A1 in Northumberland: Morpeth to Ellingham

Scheme Number: TR010059

7.28 Applicant's Responses to Deadline 7 Submissions

Applicant's Responses to Deadline 7 Submissions

Figure 3 - Geomorphological Map of the Area around the Proposed Site

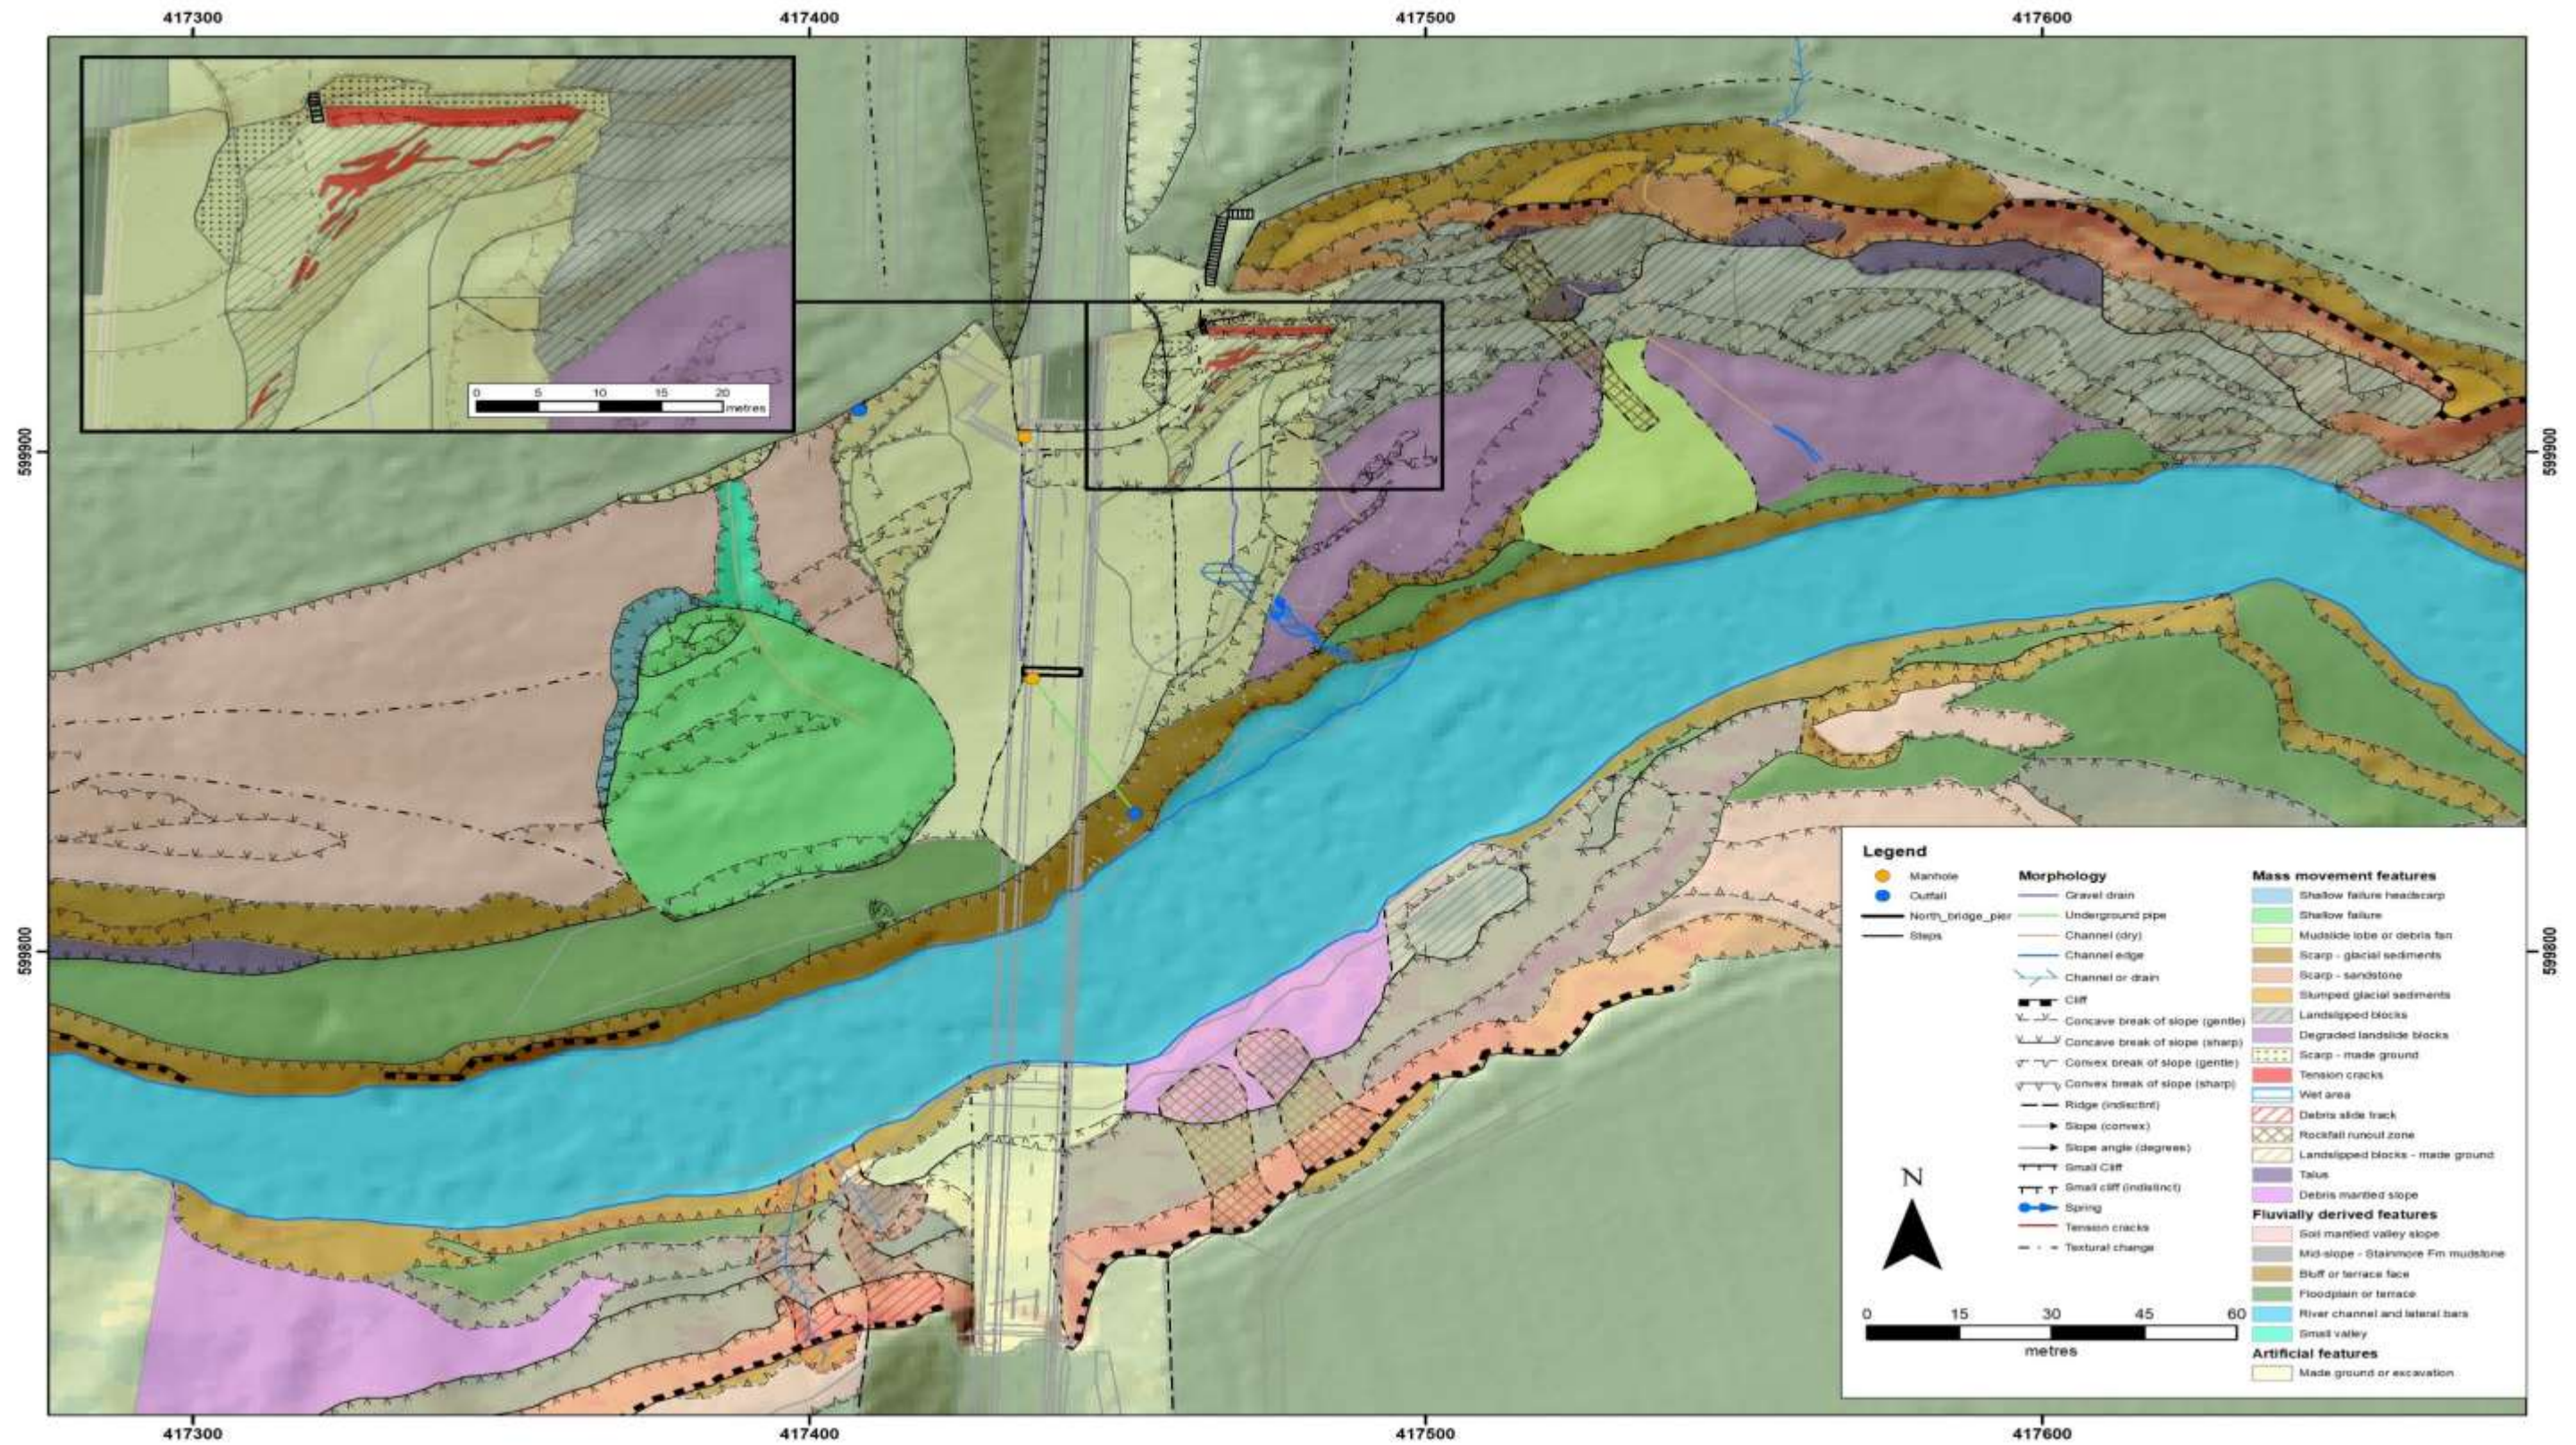
Ref. No 78, Appendix i Geomorphological Map		
4	The map only covers the area of the new bridge, and the reach directly adjacent to it. The map should include coverage for the whole reach included within the geomorphology walkover survey (between Felton weir, and Otter House). We request that geomorphology matters are pulled together to form a section in the updated geomorphological assessment. This should include a narrative on the stability of the gorge slopes, the interaction with the river and why the Applicant believes the proposed works to the north and south banks will not result in a deterioration of the river is pulled together to form a section of the updated geomorphological assessment.	<ol style="list-style-type: none">1. Appendix A of the River Coquet Fluvial Geomorphology Assessment for Change Request [REP7-003] includes geomorphological and biotope mapping of the reach and the extents of the walkover survey completed to support the assessment.2. Appendix A - River Coquet Fluvial Geomorphology Assessment – Valley Side-Channel Connectivity provides a narrative on the stability of the gorge slopes, the interaction with the river and why the Applicant considers that the proposed works to the north and south banks will not result in a deterioration of the river has been produced.

Ref. No.	Response:	Applicant's Response:
15	The map only covers the area of the new bridge, and the reach directly adjacent to it. The map should include coverage for the whole reach included within the geomorphology walkover survey (between Felton weir, and Otter House)	1. Appendix A of the River Coquet Fluvial Geomorphology Assessment for Change Request [REP7-003] includes geomorphological and biotope mapping of the reach and the extents of the walkover survey completed to support the assessment.
16	We welcome the narrative regarding the role the slopes of the gorge (River Coquet) have and are continuing to play in the supply of sediment, channel planform and flow dynamics. We request that the responses regarding this topic are pulled together to form a section in the updated geomorphological assessment. In particular, the updated geomorphological assessment should include a narrative on the stability of the gorge slopes, the interaction with the river and why the Applicant believes the proposed works to the north and south banks will not result in a deterioration of the river is pulled together to form a section of the updated geomorphological assessment.	1. Appendix A - River Coquet Fluvial Geomorphology Assessment – Valley Side-Channel Connectivity provides a narrative on the stability of the gorge slopes, the interaction with the river and why the Applicant considers that the proposed works to the north and south banks will not result in a deterioration of the river has been produced.
